Your Ref: OWPC25751
Our Ref: BN/128/19/OUT 06-12-2019
Please ask for:
Amy Myer

Application for outline planning permission for development of 70 bed Care Home and 14 Assisted Living bungalows with associated car parking, landscaping and access -
Departure from the Development Plan.

Land Adjacent to Highfield House Yapton Road Barnham

Thank you for your internet representation made on 13th February 2020 which has been recorded as '**an objection**' with the comments as follows:

DATE  
JULY 2019  
JOB / DRWG No  
1693 / SP1

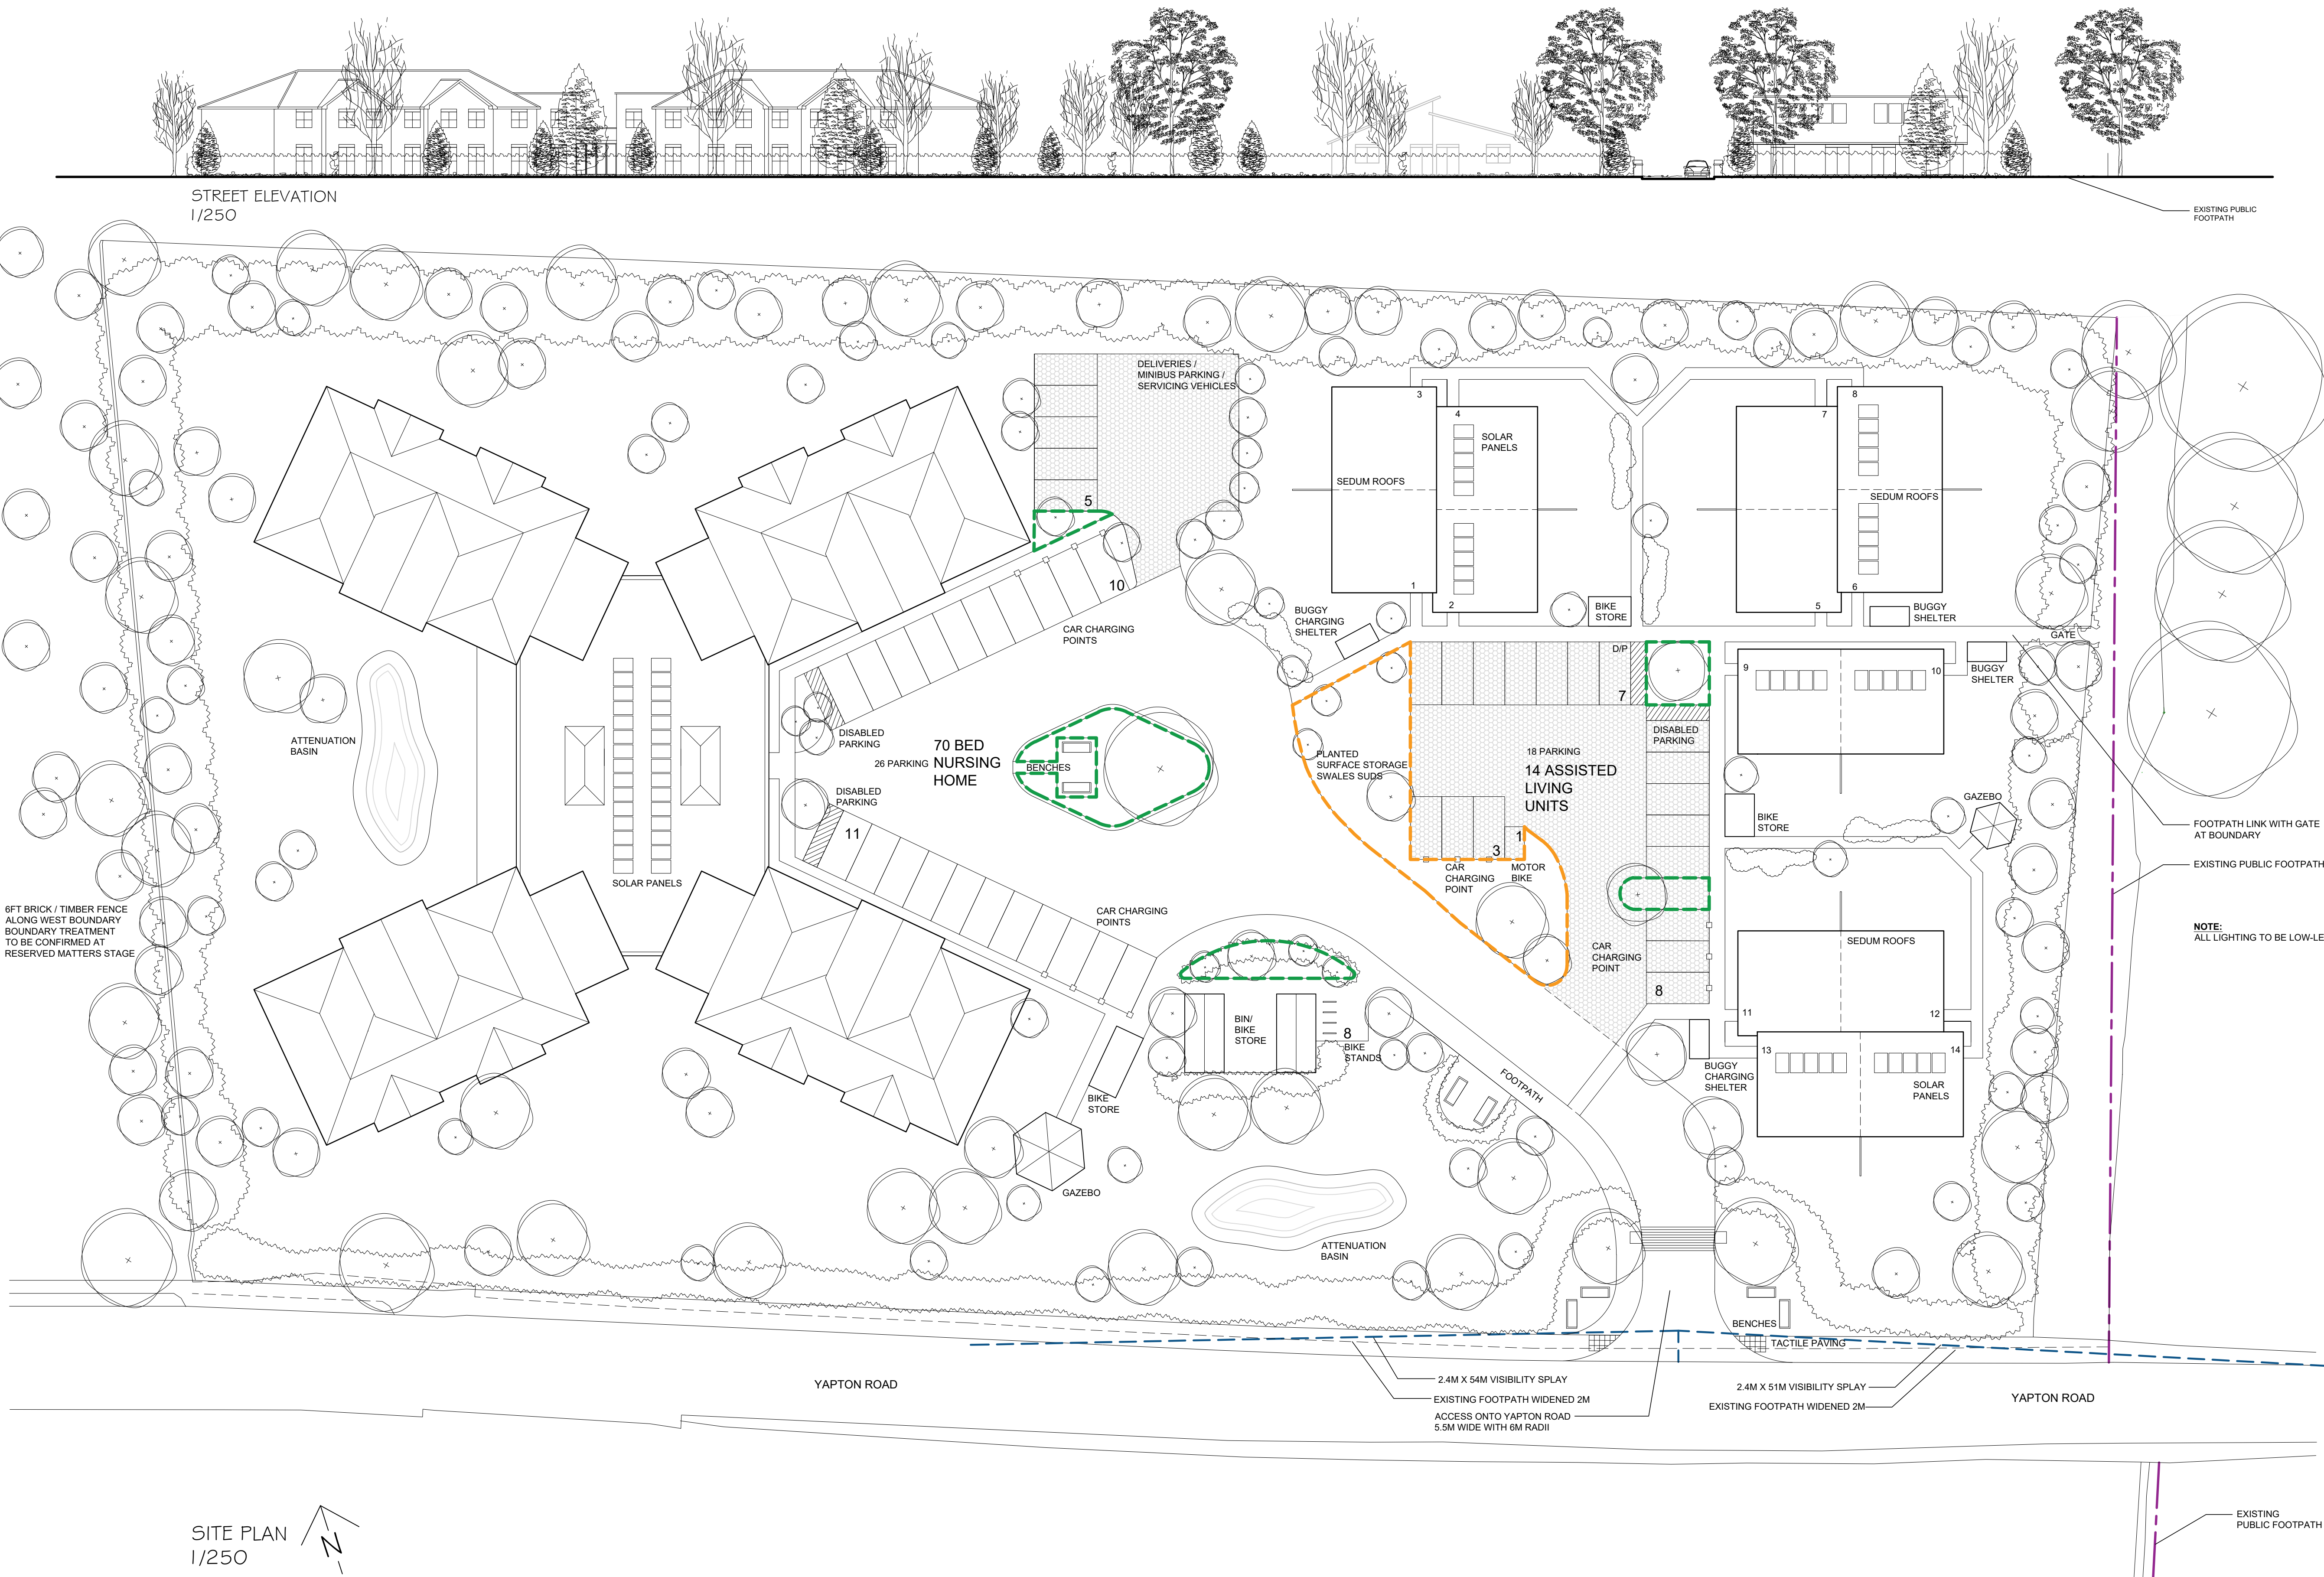
Potential 24hr use from the proposed care home bringing unwanted excessive noise and light pollution.

The removal of a significant amount of the natural hedgerow to accommodate the entrance access.

Extra congestion and road safety concerns due to the entranceway opposite onto an already busy road.
